**From:** Billington and Langho Parish Clerk <blparishclerk@outlook.com>  
**Sent:** 17 October 2018 20:00  
**To:** planning  
**Subject:** Objections to 3/2018/0837

Application 3/2018/0837

Drawing Title  
**Proposed Site Plan and Longsight Road**

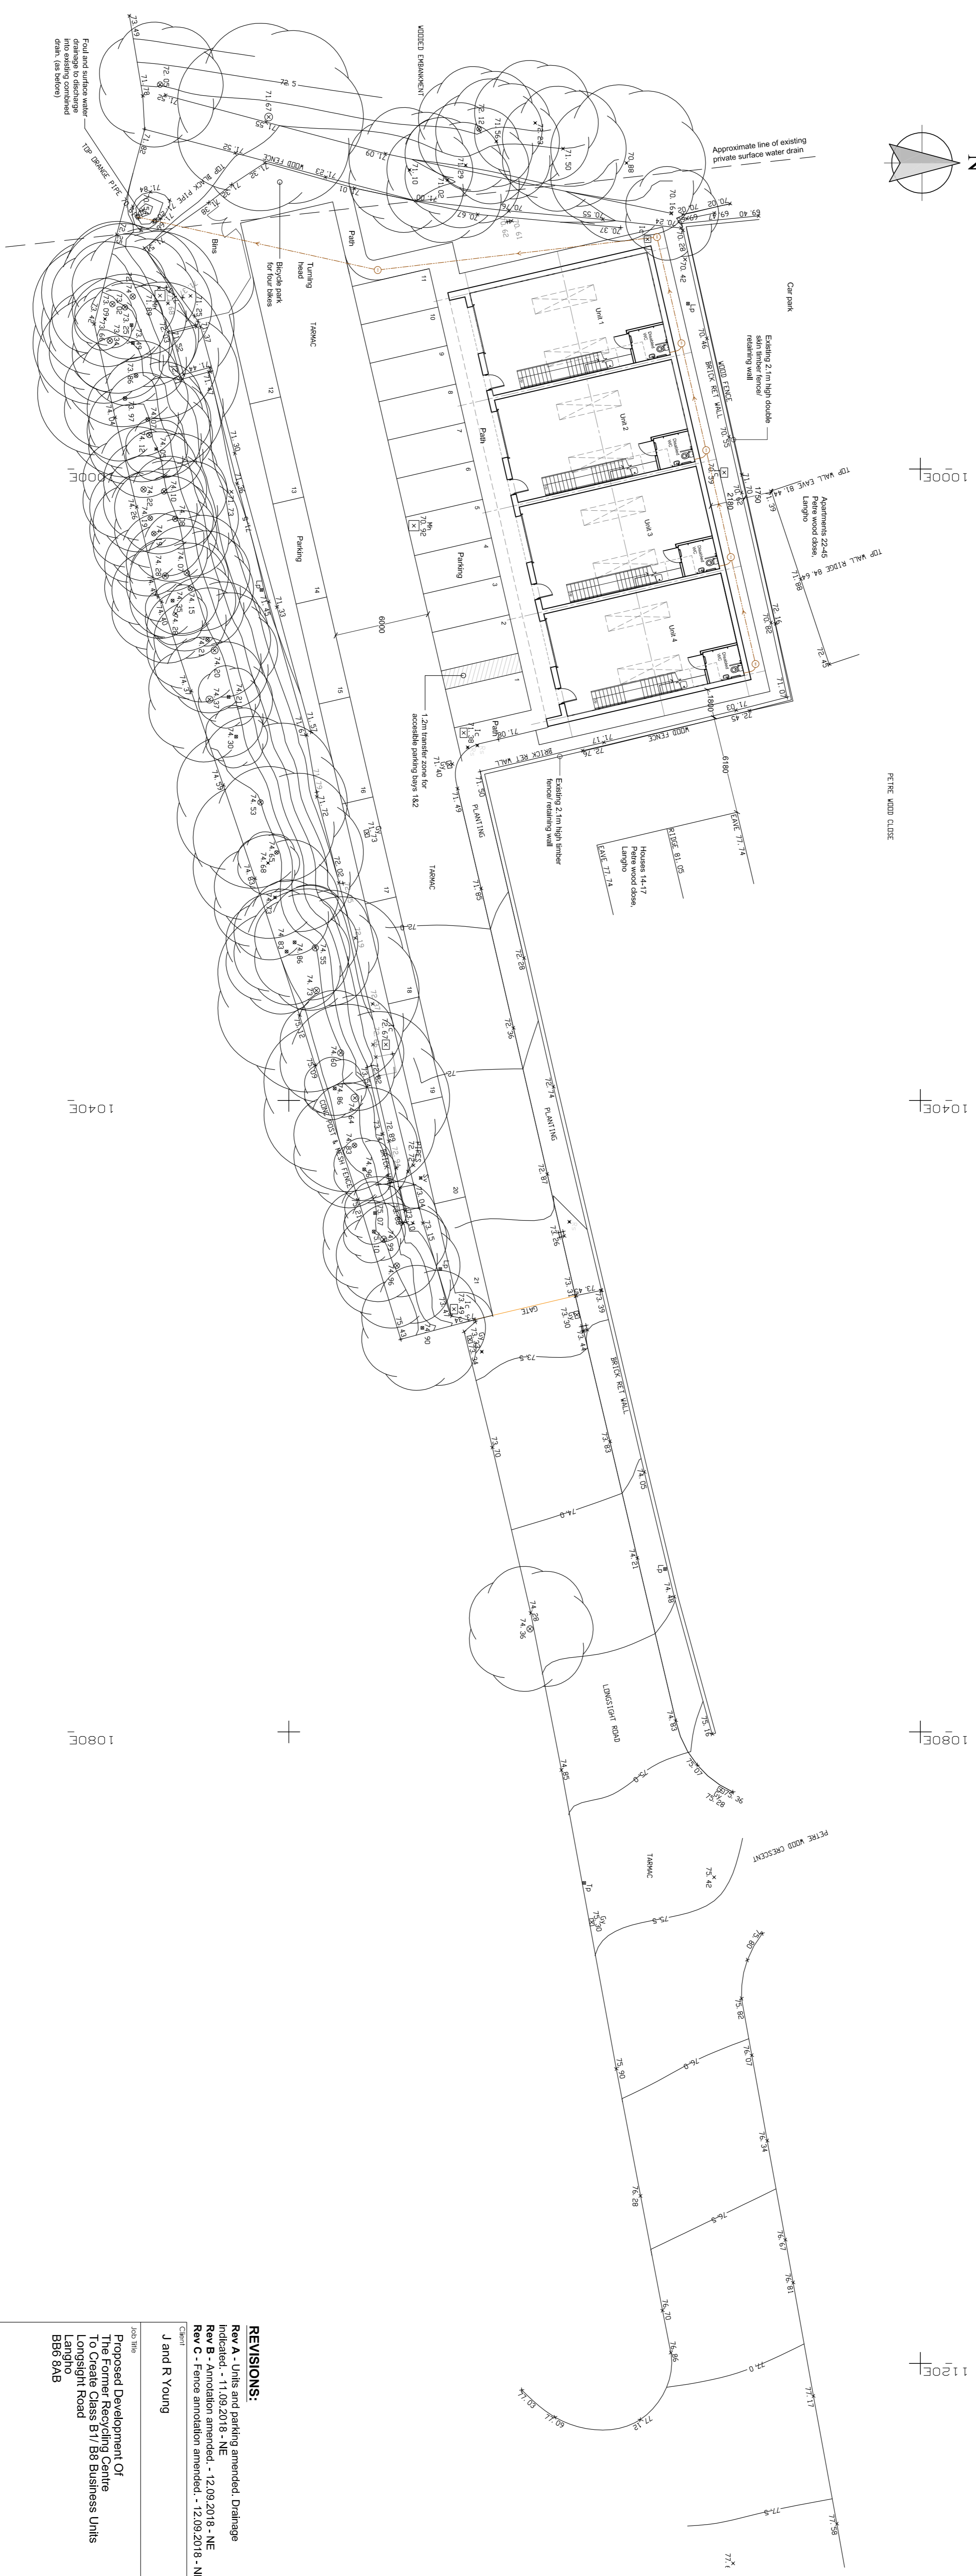
In agreement with the highway's response concerns were raised regarding the entry and exit to the site would be done by larger vehicles. The reversing of wagons or larger vehicle onto the site poses an unacceptable hazard to any pedestrians, who have no pedestrian access, and will cause an obstruction on the access road. There does not appear from the plans that wagons and larger vehicles will be able to access the site in a forward gear. It should be noted that children going to and from the local school will need to pass the entrance to the site.
